Reference No:	<b>2023/62/93588/E</b>
Site Address:	Pie Shed, 1, Green Lane, Westborough, Dewsbury, WF13 4DJ
Description:	Alterations to convert shop/cafe/storage to 8 flats
Recommending Officer:	Edward Cheseldine

**DECISION - REFUSE**

2023/93588 - Pie Shed, 1, Green Lane, Westborough, Dewsbury, WF13 4DJ

PROPOSED REAR ELEVATION

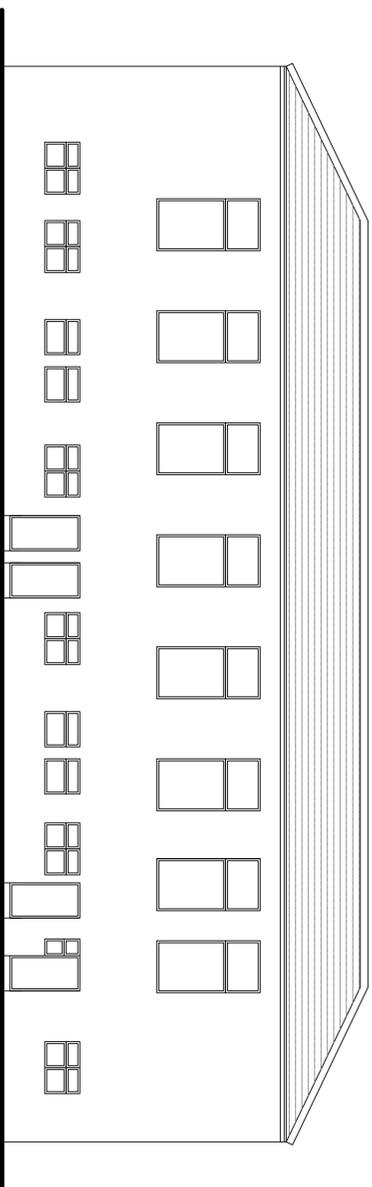
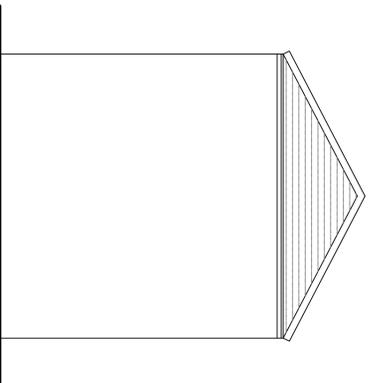
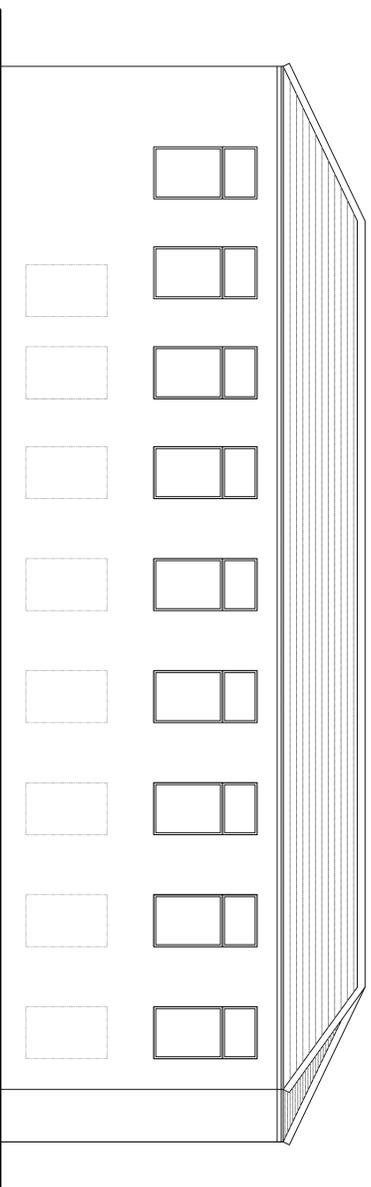
- There will be an overlooking impact from the openings on the west elevation.

The building would undergo alterations consisting of reopening two windows on the first-floor, west elevation and new openings on the ground floor west elevation. On the east elevation, new openings would be formed on the ground floor. These windows relate to the size and style of the existing sash openings. Additionally, new entranceways would be formed on the west elevation, with the existing garage style opening closed up.

130 Staincliffe Road is the immediate dwelling to the west of the application site. The west boundary elevation of the application building forms the boundary between the sites, which currently has tall evergreen trees climbing up the side of the building to create separation. Within the west facing wall a bricked up opening would be re-opened to serve Flat no.5. This and an existing opening would have an immediate view into the occupants of 130 Staincliffe Road's private amenity space. Notwithstanding the above, the relationship of the property is very close, there is an angle of outlook into habitable rooms of No. 130 from some of the windows at a 45oC angle of outlook. The relationship would compromise the privacy of 130 Staincliffe Road which fails to accord with LP 24 (c) & Principle 6 of the Kirklees Housebuilders Design Guide SPD by way of detrimentally impacting the privacy of neighbouring occupants.

Taking into account the existing situation as a consideration in the assessment of the impact of the proposed development on residential amenity, whilst it is noted that the submitted plans show what appears to be an existing ancillary flat at the first floor level with the existing openings on the western elevation serving that living accommodation, Google Streetview images from October 2020 to June 2023 show these openings to be covered substantially by ivy. As such, the proposed development would result in an overlooking impact over and above that which has existed in recent years.

PROPOSED FIRST FLOOR PLAN

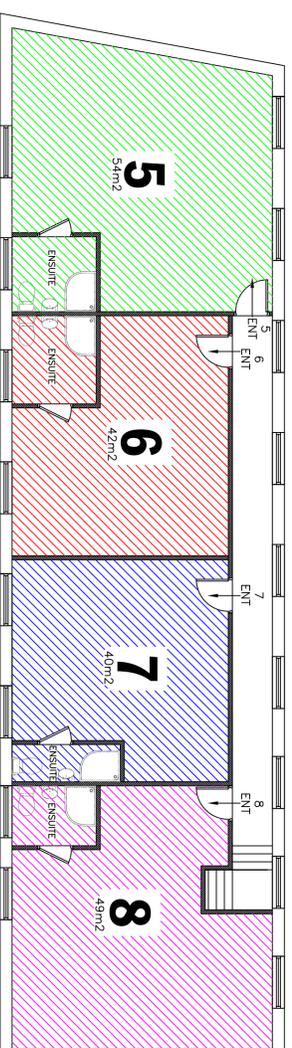
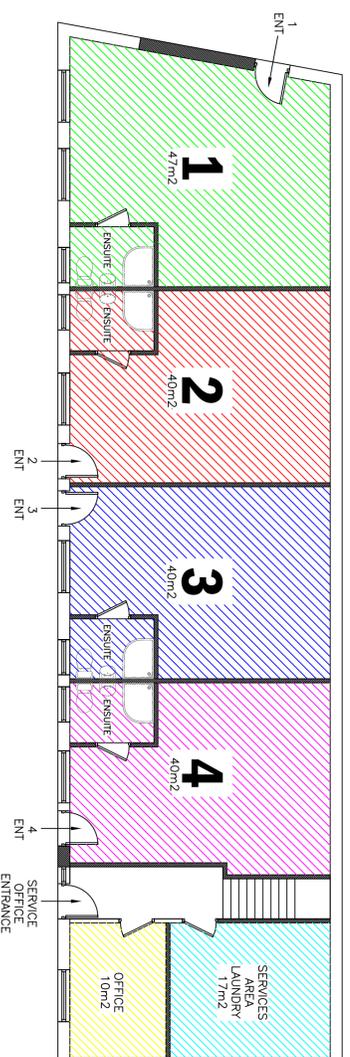
In respect of the Technical housing standards – nationally described space standards, the units would accord with the required minimum floorspace (39 sqm) for a 1 bed, 1 person flat, with the exception of Flat no.5 which would be over the threshold for a 1 bed 2 person flat. Notwithstanding this, Officers consider that the majority of the units would have a poor outlook with only one window opening to the east elevation, particularly those at ground floor level which would face a car park with palisade fence at close quarters. In addition, the window in the west elevation at first floor level serving Flat No.8 would face directly onto the gable end of No.130 with only a very small gap of separation. On this basis, the proposals, by virtue of their layout and design, would fail to provide appropriate living conditions to future occupiers with reference to daylight and outlook, resulting in a poor standard of amenity contrary to Policy LP24 of the KLP and the key design principles of the Housebuilders Design Guide SPD.

No bin storage facilities have been indicated on the plans, if there were no outstanding issues, a designated storage facility would be a requirement of approval.

1. The proposed development, by virtue of its layout and design, would fail to provide appropriate living conditions to future occupiers with reference to daylight and outlook, resulting in a poor standard of amenity. To permit the development would be contrary to Policy LP 24 of the Kirklees Local Plan, Principle 6 of the Kirklees Housebuilders Design Guide SPD & paragraph 135 of the NPPF.
1. The proposed development, by virtue of its layout and design, with particular reference to Unit 5, would result in a loss of privacy to the occupiers of 130 Staincliffe Road, contrary to Policy LP24 of the Kirklees Local Plan, Principle 6 of the Kirklees Housebuilders Design Guide SPD & paragraph 135 of the NPPF.
